From: Amanda Scholes on behalf of Planning.Responses
Sent: 30 March 2021 10:08
To: Planning Scanning
Subject: FW: Planning Consultation on: LY/4/21/DOC

From: Paul Cann <Paul.Cann@arun.gov.uk>
Sent: 29 March 2021 15:46
To: Planning.Responses <Planning.Responses@arun.gov.uk>
Cc: Finlay Gardner <Finlay.Gardner@arun.gov.uk>
Subject: RE: Planning Consultation on: LY/4/21/DOC

(Relating to condition no.3 of LY/10/17/PL)

Application No: LY/4/21/DOC
Registered: 10th March 2021
Site Address: Comfort Inn Lyminster Road Lyminster BN17 7QQ
Description of Works: Approval of conditions imposed under LY/10/17/PL relating to condition 3-surface water drainage.

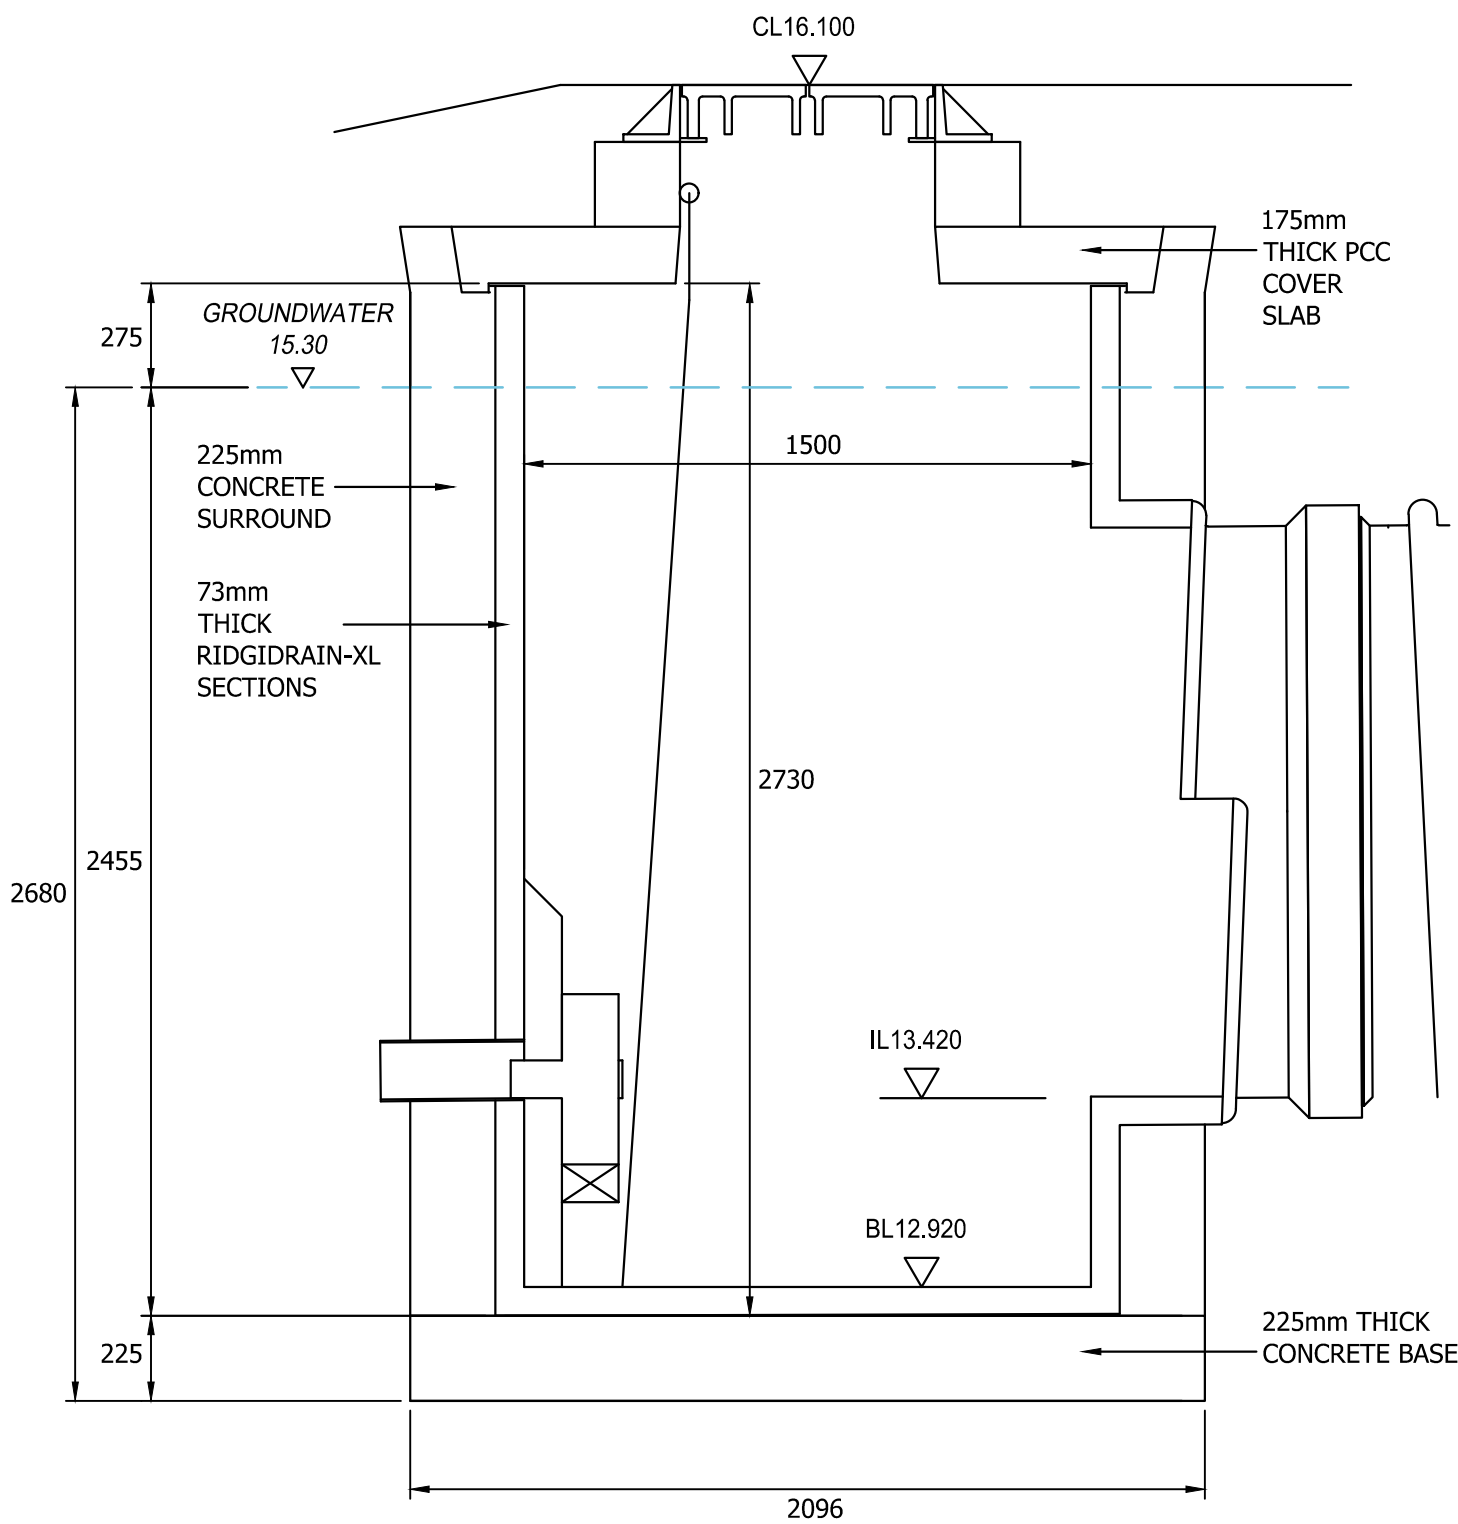
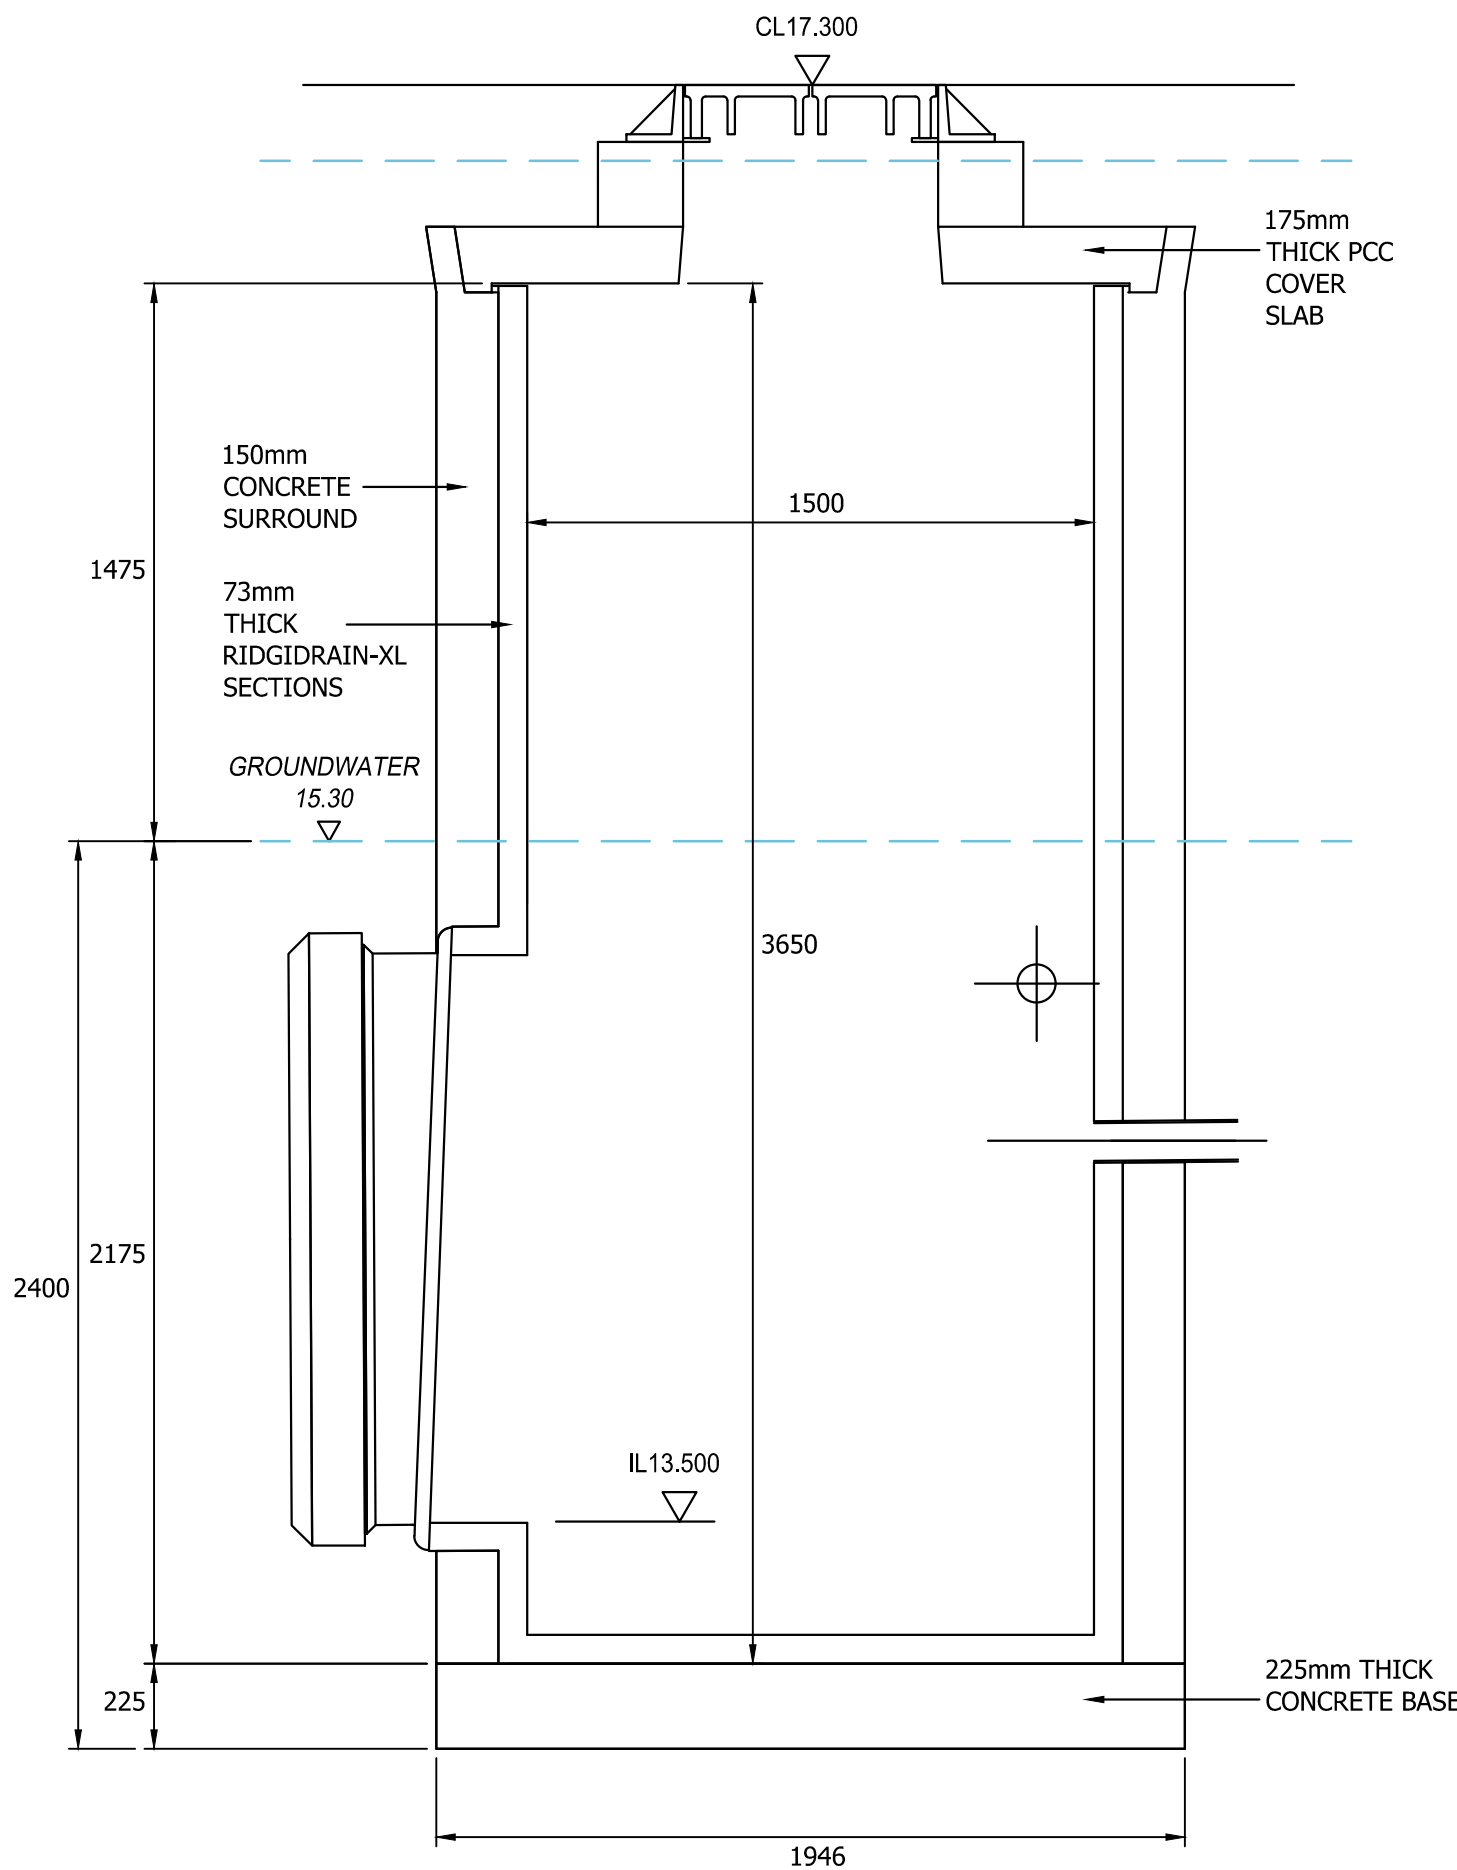
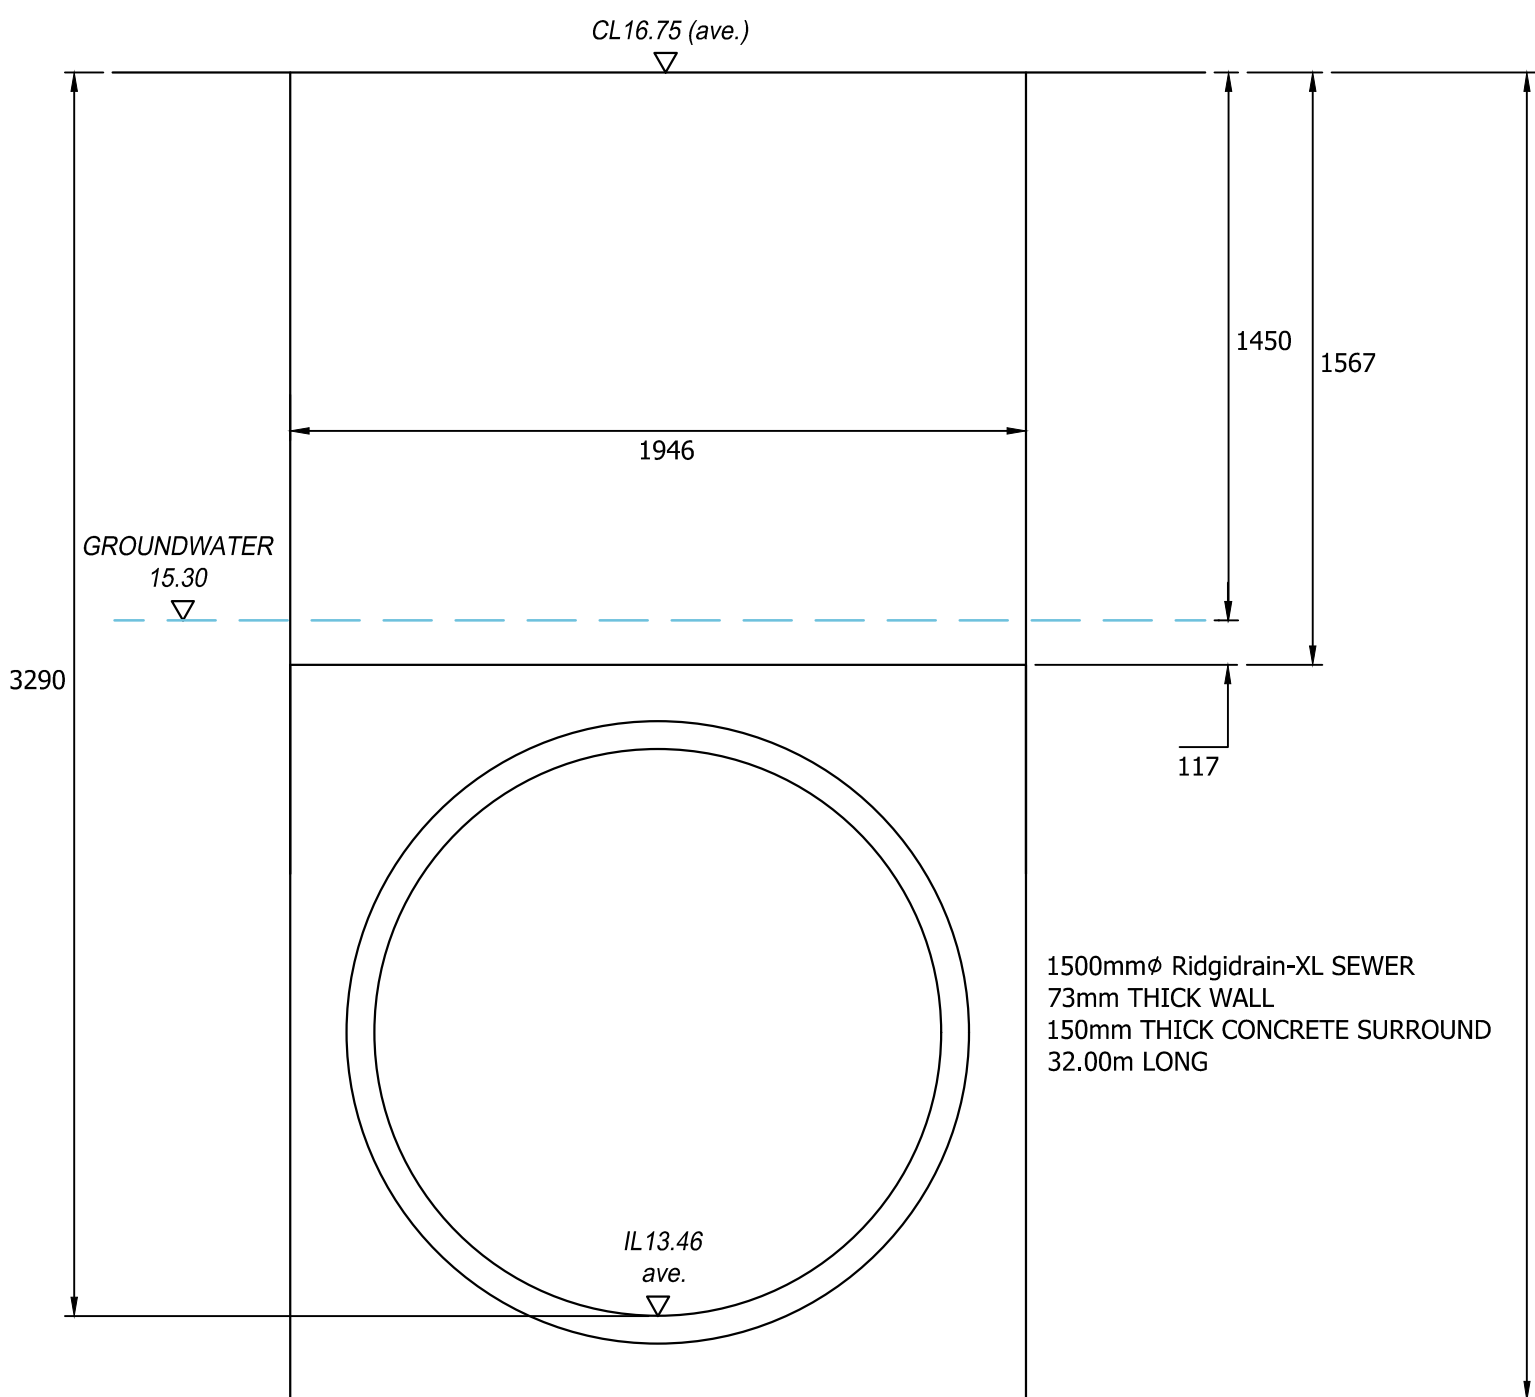
2. Make it clear in terms of the construction detail being referred to for the new manhole to be constructed on the existing 150mm pipe.
3. Specify the invert level of the existing 150mm pipe where it discharges to the existing ditch. Also, the invert level of the manhole upstream of where the pipe is being connected to. Specify the actual invert level at the point of connection, ensuring that the 100mm pipe connects at soffit to soffit level with the 150mm pipe.
4. Specify the actual gradient of the pipe between the control chamber and the new manhole on the existing 150mm pipe.
